ECCO

October 21, 2022

**Re: Permit #** SHL18-017  
**Project Name** Lakeshores Group Community Dock  
**Project Address** 5067 84<sup>th</sup> Ave SE (parcel # 407600-0080)  
**Reviewer** Andrew Leon, Planner  
**Department** Planning & Development

SITE PLAN
(PROPOSED)
 SCALE 1" = 40'-0"

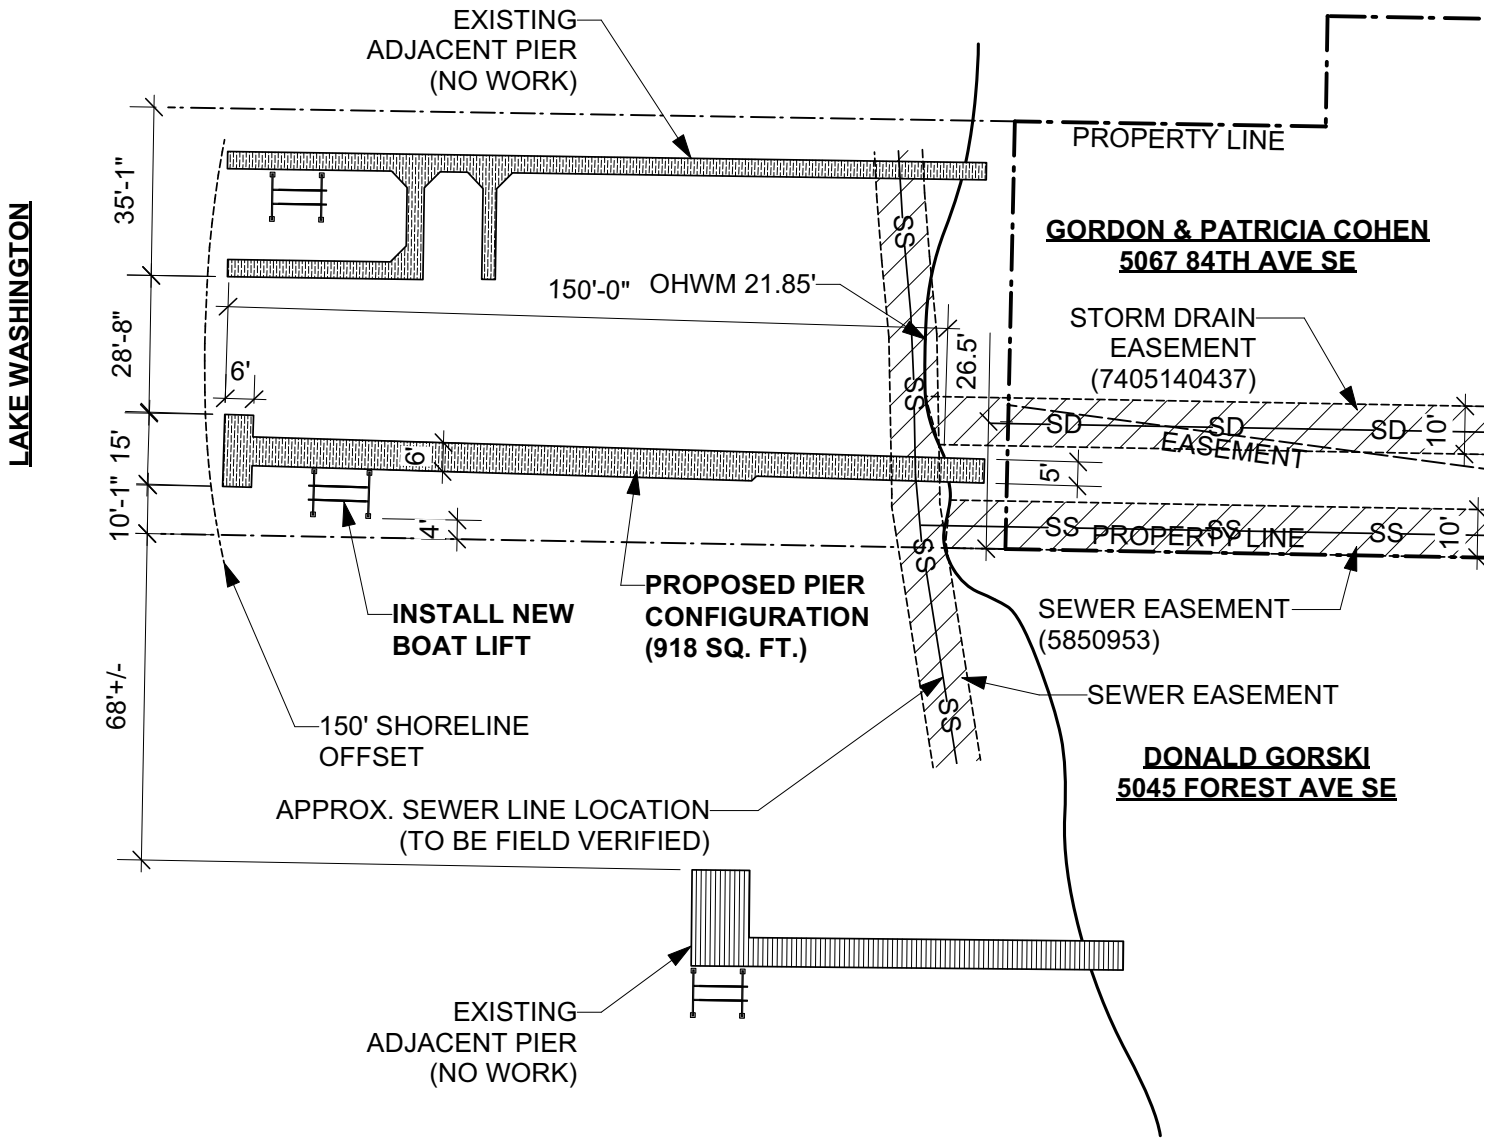
***1. The proposed boat lift is located within the 10-foot lateral line setback from the lateral line to the south. Table D of MICC 19.07.110(E)(4) states that moorage facilities may only be located within the setback from a lateral line if the moorage facility is built pursuant to an agreement between adjoining property owners. Boat lifts are included in the definition for moorage facility, so an agreement, in writing, between the owner of the subject property and the property to the south will be required to install the boat lift in the proposed location.***

Table D of MICC 19.07.110 (E)(4) states that docks, covered moorages, and floating platforms may only be located within the setback from a lateral line if built pursuant to an agreement between adjoining property owners. Excluded from that requirement are boat lifts. Previously approved shoreline substantial development permits SHL20-023 and SHL20-045 both allowed boat lifts in the setback without an agreement with the adjoining property owners. Why is it being required for this project when it was not for these projects?
